Reinforcement to the North Shropshire Electricity Distribution Network

Application Reference: EN020021

**SP Manweb's Responses to the Examining Authority's
First Written Questions**

Application by SP Manweb for Reinforcement to the North Shropshire Electricity Distribution Network
The Examining Authority's written questions and requests for information (ExQ1)
Issued on 27 March 2019

Diagram 3.2 – Illustration of different Trident pole types

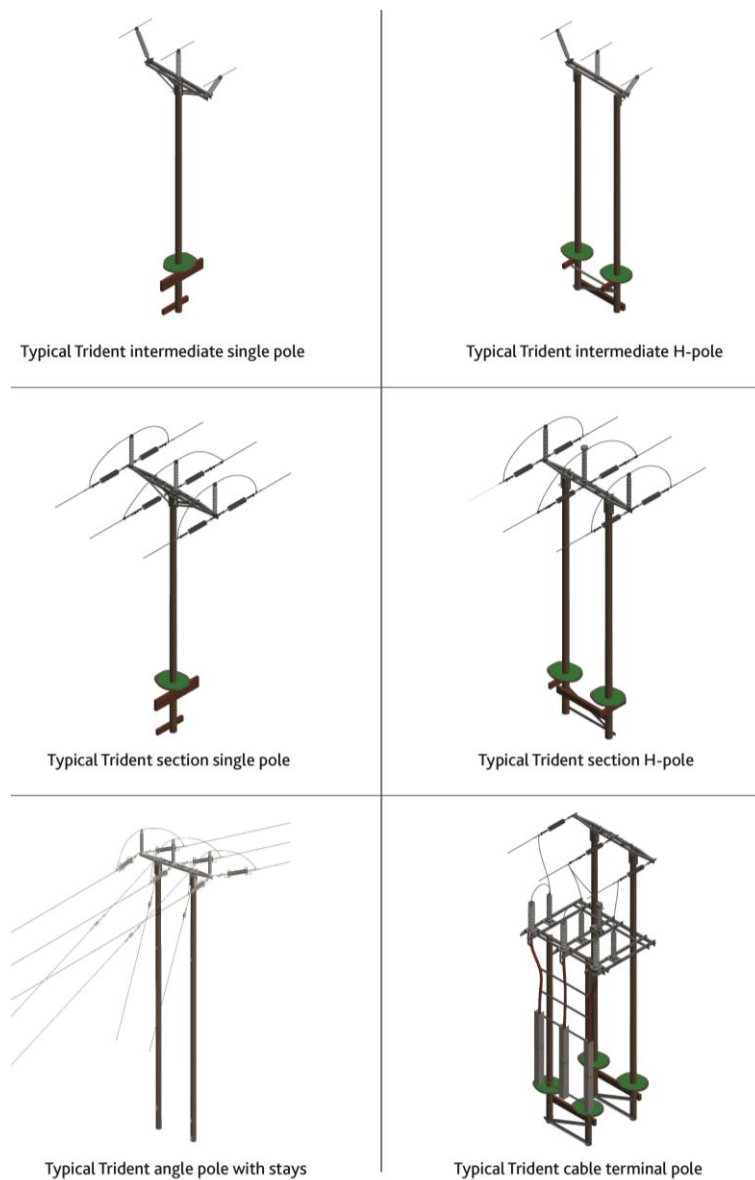
Q7.0.4	The Applicant	<p>Description of pole types</p> <p>There are inconsistencies between the description of pole types in column 4 of Table 1 of R3 of the draft DCO [APP-012], and the description of the pole types in chapter 3 of the ES [APP-034]. R3 of the draft DCO refers to 7 pole types and these are consistent with the description of 7 pole types shown in Table 3.1 of APP-034, apart from the Terminal H-pole which is presumably the same as the Double H-pole. However, Diagram 3.2 of APP-034 illustrates 6 pole types but these do not immediately correspond to the description in the draft DCO [APP-012].</p> <p>Please provide a note which relates the description of pole types in column 4 of Table 1 of R3 of the draft DCO [APP-012] to illustrations of them and add this note to the list of documents proposed to be certified.</p>
		<p>SP Manweb agrees that there are inconsistencies in the description of pole types between Table 1 of R3 of the draft DCO, Chapter 3 of the Environmental Statement and Diagram 3.2 of APP-034.</p>

ExQ1	Question to:	Question:																					
		<p>The description of pole types in Table 1 of R3 of the draft DCO is correct. The table below provides the description of pole type from Table 1 of R3 with the corresponding description from Chapter 3 'The Proposed Development' of the Environmental Statement (DCO Document 6.3 (APP-034)):</p>

<table><tr> <th colspan="3" data-bbox="792 483 2074 571">Trident Wood Pole Structure Types</th> </tr><tr> <td data-bbox="792 738 1055 1086">Terminal H-pole</td> <td data-bbox="1055 738 1301 1086">Double H-pole</td> <td data-bbox="1301 738 2074 1086"> <p>A Terminal H Pole is a double H Pole however the Terminal H Pole includes a cable sealing end. Pole 1 (listed in Table 1 of Schedule 2 to the draft DCO (DCO Document 3.1 (APP-012)) is a Terminal H Pole.</p> <p>A Terminal H Pole is illustrated as 'Typical Trident cable terminal pole' in Diagram 3.2 of Chapter 3 of the ES 'The Proposed Development' (DCO Document 6.3 (APP-034)).</p> </td> </tr><tr> <td data-bbox="792 1086 1055 1174">Intermediate</td> <td data-bbox="1055 1086 1301 1174">Intermediate (2.5m arm)</td> <td data-bbox="1301 1086 2074 1174">Illustrated as 'Typical Trident intermediate single pole' in Diagram 3.2</td> </tr><tr> <td data-bbox="792 1174 1055 1262"></td> <td data-bbox="1055 1174 1301 1262">Intermediate H-pole</td> <td data-bbox="1301 1174 2074 1262">Illustrated as 'Typical Trident intermediate H pole' in Diagram 3.2</td> </tr><tr> <td data-bbox="792 1262 1055 1350">Section</td> <td data-bbox="1055 1262 1301 1350">Section Single</td> <td data-bbox="1301 1262 2074 1350">Illustrated as 'Typical Trident section single pole' in Diagram 3.2</td> </tr><tr> <td data-bbox="792 1350 1055 1447"></td> <td data-bbox="1055 1350 1301 1447">Section H-pole</td> <td data-bbox="1301 1350 2074 1447">Illustrated as 'Typical Trident Section H single pole' in Diagram 3.2</td> </tr></table>
